**KIRKLEES METROPOLITAN COUNCIL  
TOWN AND COUNTRY PLANNING ACT 1990  
HIGHWAYS DEVELOPMENT CONTROL KP20H**

**PLANNING REF** 2015/62/90435/E0/SD  
**CATEGORY** Small Major

**PROPOSAL** ERECTION OF 14 DWELLINGS  
WITH INTEGRAL GARAGES

**LOCATION** PARKHAM FOODS LTD  
22 HALIFAX ROAD  
MILLBRIDGE  
LIVERSEDGE  
WF15 6JQ

Client:	Swift Property Management and Consultancy	
Project:	Former Parkam Foods Site Residential Development	
Drawing:	Site Layout	
Date:	Feb 2015	Scale: 1:500@A3
Drawing No:	1434/110	Rev: C

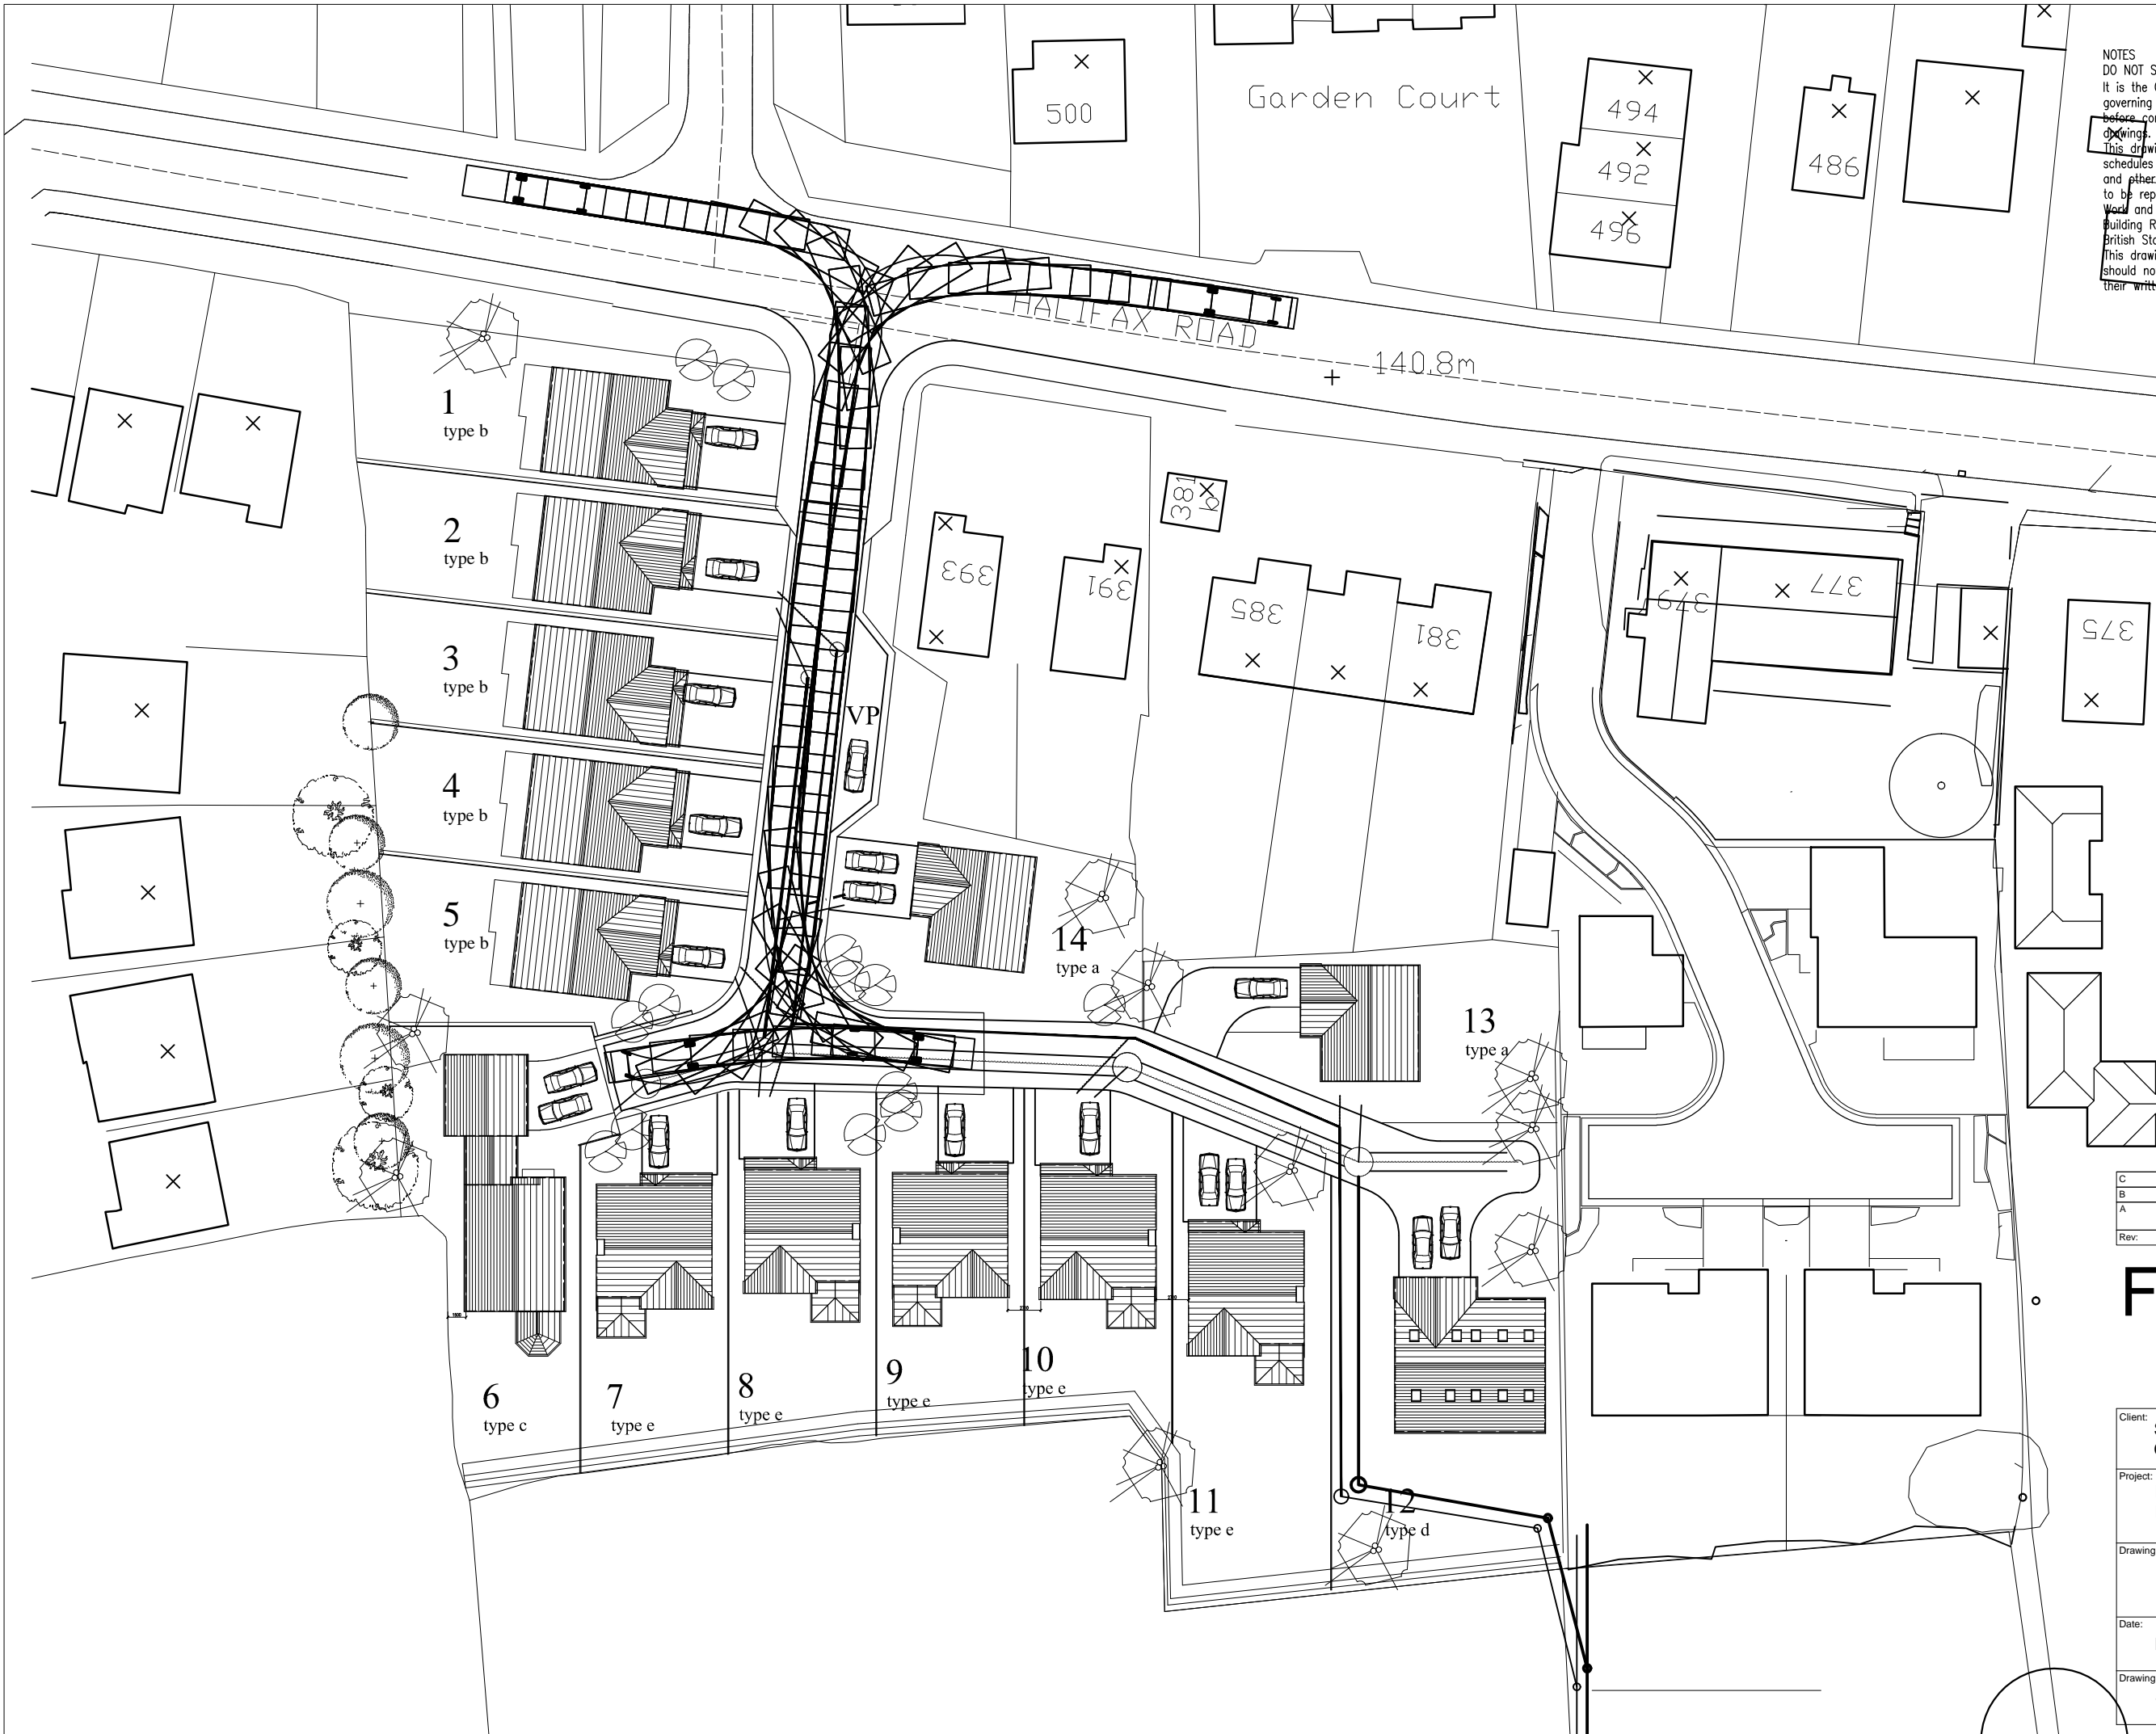
The development will be served from a single access point onto the A649 Halifax Road on the opposite side of Halifax Road from Aquila Way which a cul-de-sac serving 18 properties.

Sight lines onto Halifax Road are good in both directions and this proposal provides sufficient off-street parking including visitor parking and internal refuse vehicle turning.

These proposals are considered acceptable from a highways point of view and we have no wish to resist the granting of planning permission.

No development shall take place until a scheme detailing the proposed internal adoptable estate roads have been submitted to and approved in writing by the Local Planning Authority. The scheme shall include full sections, drainage works, street lighting, signing, surface finishes and the treatment of sight lines, together with an independent safety audits covering all aspects of work. Before any building is brought into use the scheme shall be completed in accordance with the scheme shown on approved plans and retained thereafter.

No building shall be occupied until the existing access from Halifax Road has been permanently closed [and any redundant footway crossings removed and the footway reinstated] and the new access has been constructed and brought into use in accordance with details that have previously been approved in writing by the Local Planning Authority.
